Rezoning Transportation Analysis
Petition Number: Insert Zoning Petition #2021-012
General Location Identifier: Tax ID 10304112

Revision Log:	Date	Description
	02-25-2021	First Review (WB)
	03-25-2021	Second Review (WB)
	04-28-2021	Third Review (WB)

SCHEMATIC
SITE PLAN

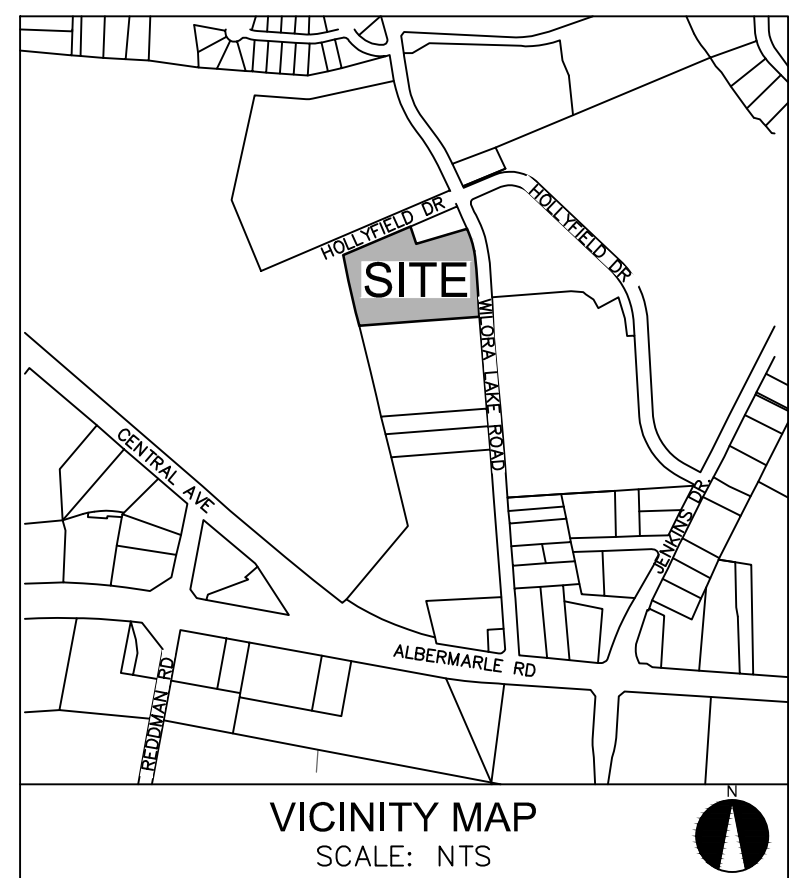
3. The site plan commits to construct an 8-foot planting strip, 8-foot sidewalk along the site's Wilora Lake Road frontage leaving a sidewalk gap of less than 100' north of the site. Revise site plan and conditional note(s) to commit to extend the proposed 8-foot planting strip and 8-foot sidewalk to the Hollyfield Drive intersection and tie into the newly constructed ADA curb ramps to assist CDOT in close a gap in pedestrian infrastructure.

The site plan shall label and dimension both items from the back of curb and gutter.

4. Revise site plan and conditional note D.6. to commit to installing two (2) additional stop signs at the intersection of Wilora Lake Road and Hollyfield Drive, in lieu of funding the stop signs.
5. ~~Add a site plan note specifying dedication and fee simple conveyance of all rights-of-way to the City before the site's first building certificate of occupancy is issued is needed. CDOT requests rights-of-way set at 2' behind back of sidewalk where feasible. Rescinded (3/22/2021)~~
6. ~~Add a site plan note specifying that all transportation improvements will be approved and constructed before the site's first building certificate of occupancy is issued is needed. The petitioner may phase transportation improvements if said improvements and phasing are explicitly described in site plan notes. Rescinded (3/22/2021)~~
